**Re: Mixed-Use Development, 4322 4th St. NW, Traffic Circulation Layout
Engineer's Stamp dated 8-12-13 (G14-D071)**

Based upon the information provided in your submittal received 8-21-13, the above referenced plan cannot be approved for Building Permit until the following comments are addressed:

H.C. PARKING PLAN TYP.

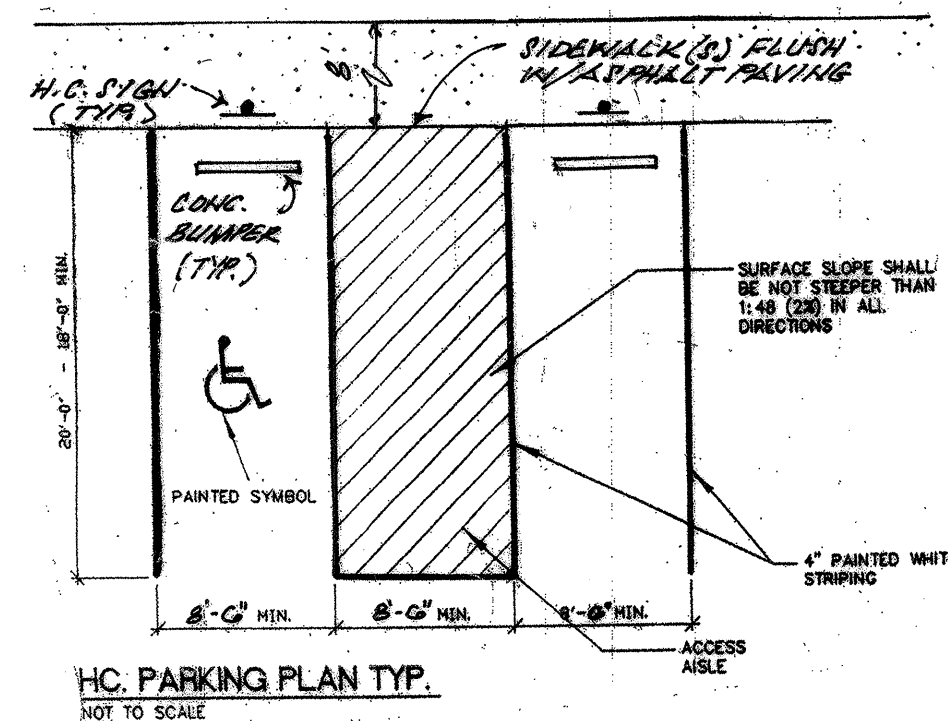
3. The handicapped spaces must include an 8-foot wide van access aisle; all other aisles must be a minimum of 5 feet in width.
4. Define width of the existing sidewalk on 4th St.

TRAFFIC CIRCULATION LAYOUT

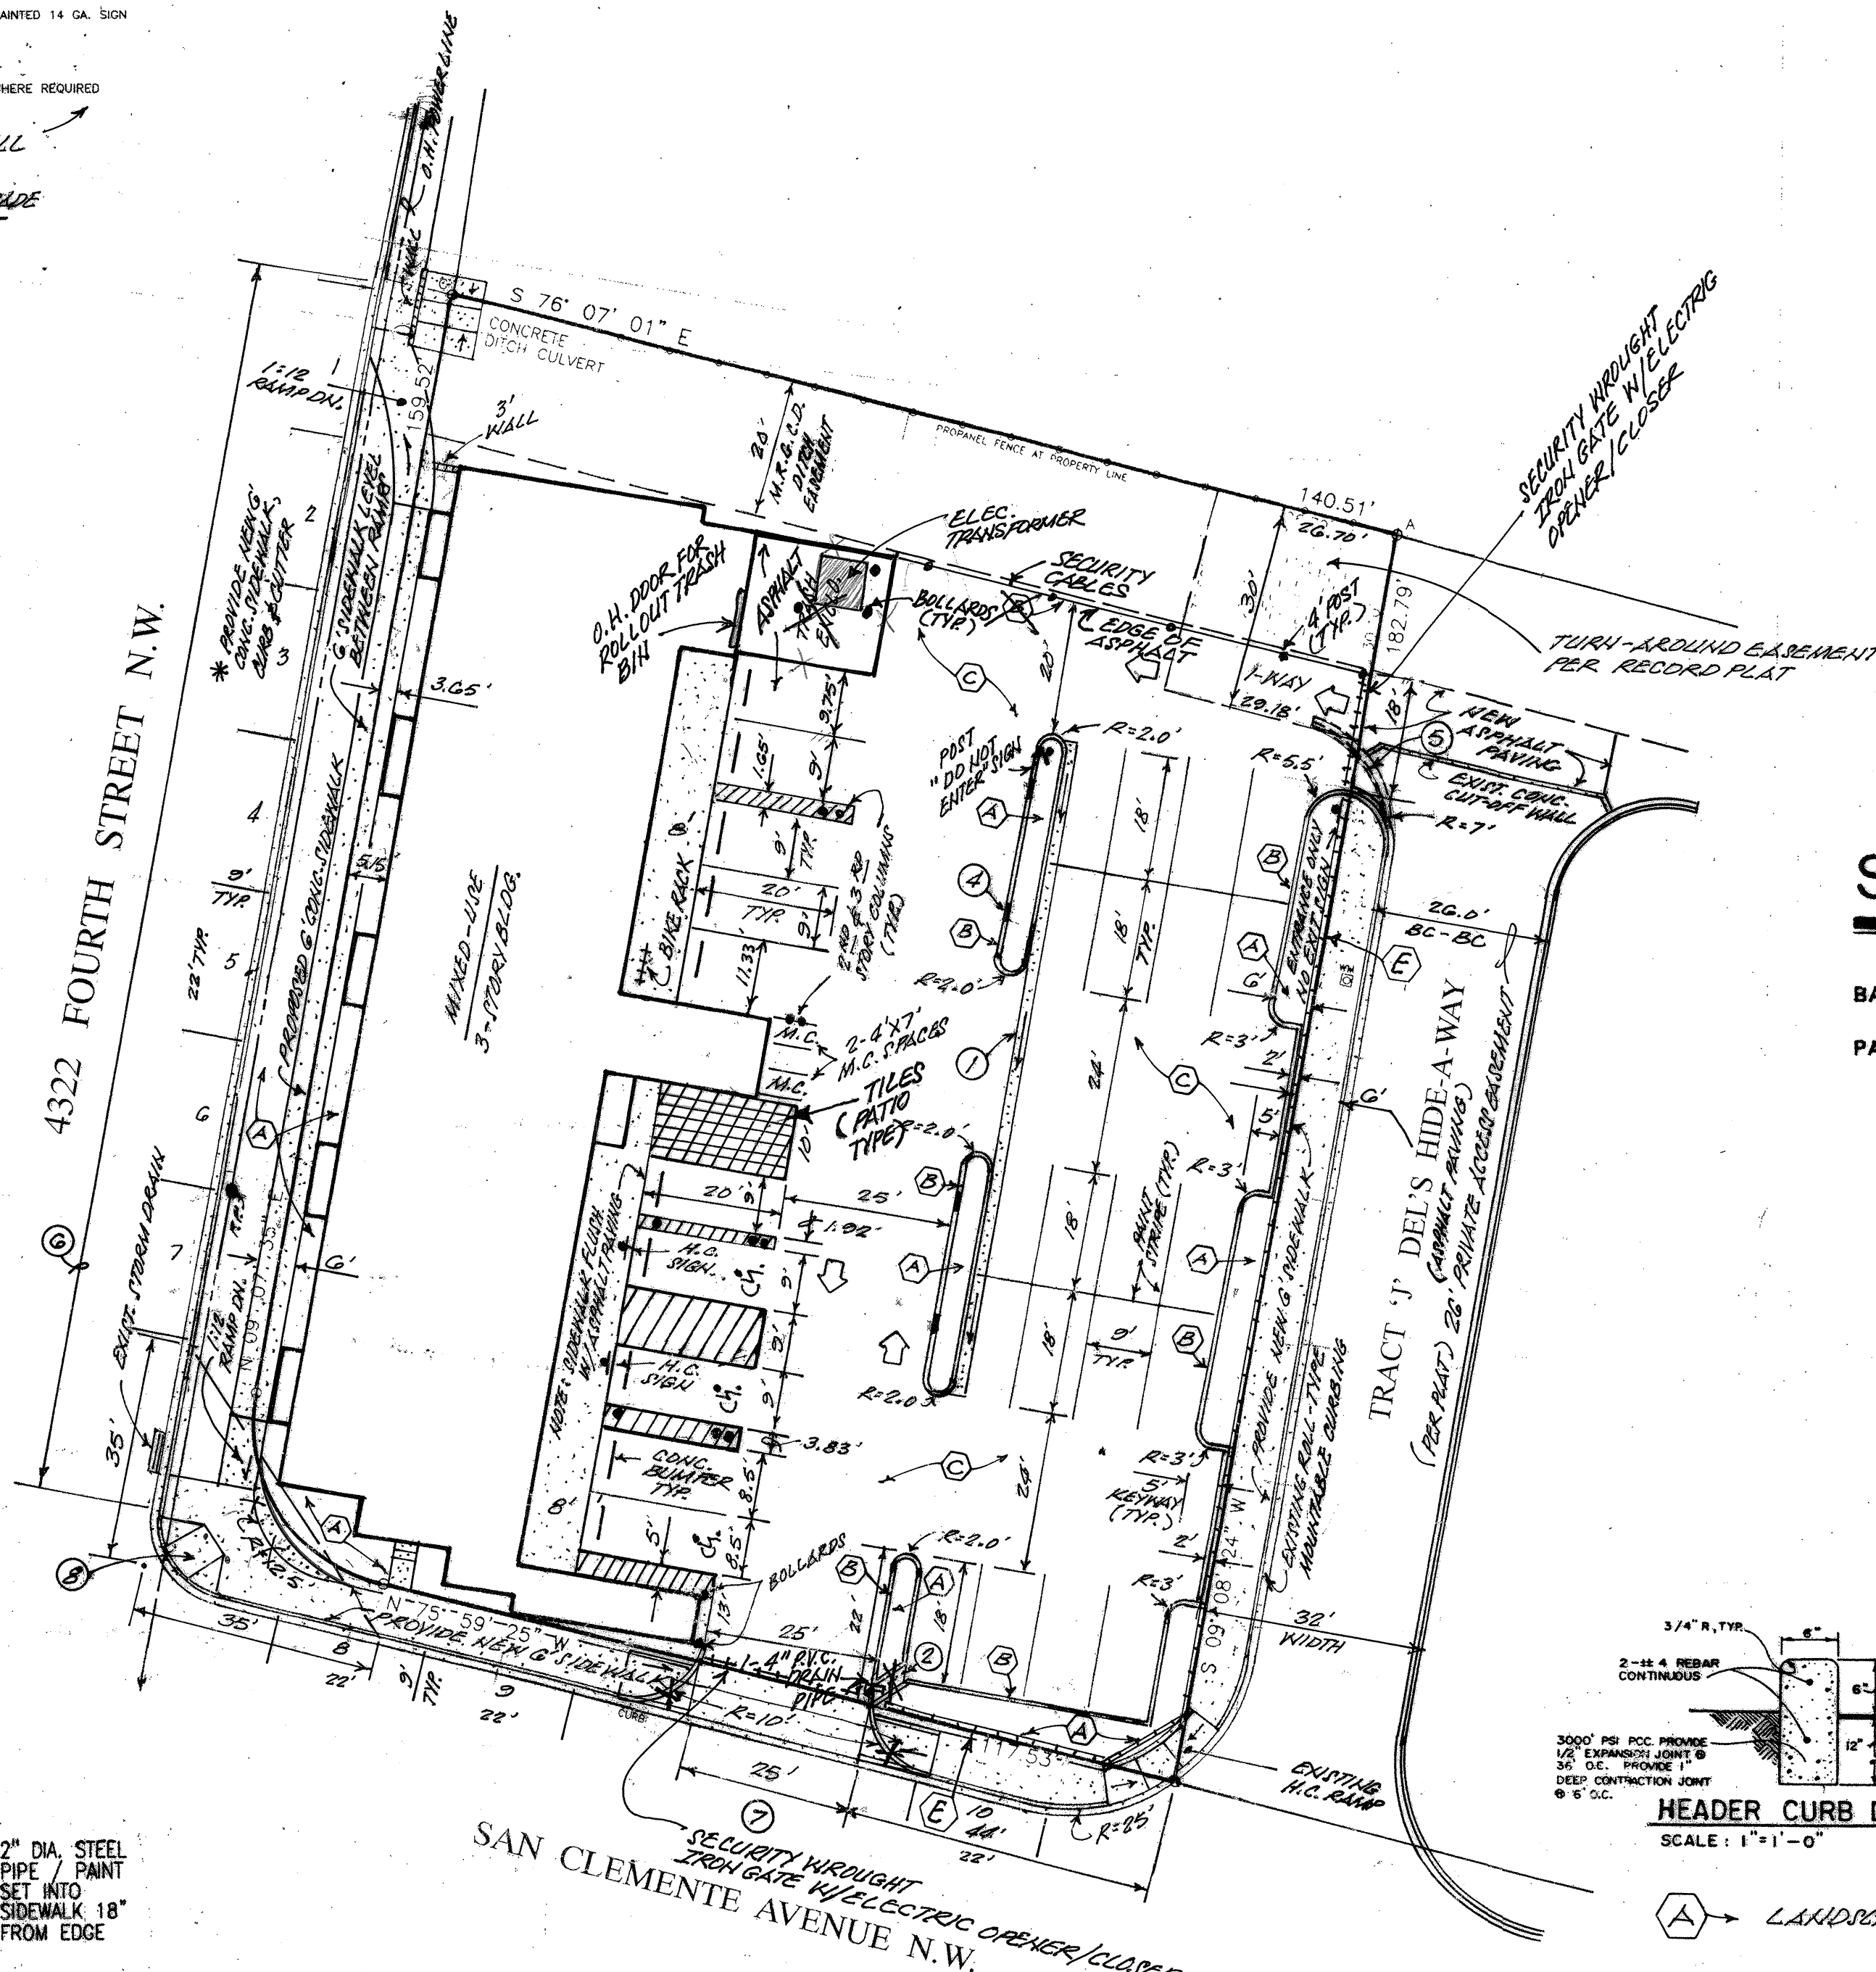
1. A five-foot keyway is required for deadend parking aisles.
2. Please list the width and length for all parking spaces or provide a "typical" dimensional detail.

5. Define the width and location of existing curb cuts on 4th St.
6. Abandon curb cuts must be replaced with sidewalk and curb & gutter. A build note must be provided referring to the appropriate City Standard (#2430 and #2415).

7. Please place the new 6' sidewalk on 4th St at the property line and not back of curb.
8. The proposed TCL appears to use the private access road adjacent to site to gain access and for street parking. Please include a copy of your shared access agreement with the adjacent property owner.

9. Please provide radius of curb return and width of road to the private access road adjacent to site.
10. On-Street parking Allowance to fulfill zoning's parking requirement must be requested and approved by the Traffic Engineer, Kristal Metro prior to TCL approval. The application requires 15 working days. On-street parking allowances are based on available parking along public right-of-ways fronting the property. The business will only be granted 50% of available street parking. The current TCL is under parked per zoning.

11. It is not apparent what type of pavement surface is being proposed. A hard driving surface will be required as part of this proposed project for parking area and drive aisles.

12. Per Chapter 23, Section 6, Part B.8.b of the City of Albuquerque *Development Process Manual*, Drive pad – Widths on Local Streets: 25 ft minimum for two-way access – 25' to 35' permitted, and 12'-20' for one-way drives (with appropriate signs and parking layout).

13. One-way vehicular paths require pavement directional signage and a posted "Do Not Enter" sign at the point of egress.
14. Please clarify the use of "A" and the typical curb details provided on TCL.

15. Is landscaping required by zoning? If so, please provide landscaping plan with next submittal. Per the *Development Process Manual*, Chapter 23, Section 7, Part B.6, curbing should be used to separate landscaping from parking areas and pedestrian ways as well as providing a physical perimeter for harvesting water. This must be clearly shown on the TCL.

16. Please add the following note: "Landscaping and signing will not interfere with clear sight requirements. Therefore, signs, walls, trees, and shrubbery between 3 and 8 feet tall (as measured from the gutter pan) will not be acceptable in this area."

17. The proposed building may interfere with the sight distance of the intersection. Please provide a sight distance exhibit (see the *Development Process Manual*, Chapter 23, Part B, Section 5.a).

19. Per the DPM, a 6 ft. wide ADA accessible pedestrian pathway is required from the public sidewalk to the building entrances. Please clearly show this pathway and provide details.
20. Per the DPM, a 6 ft. wide ADA accessible pedestrian pathway is required from the HC parking stall access aisles to the building entrances.
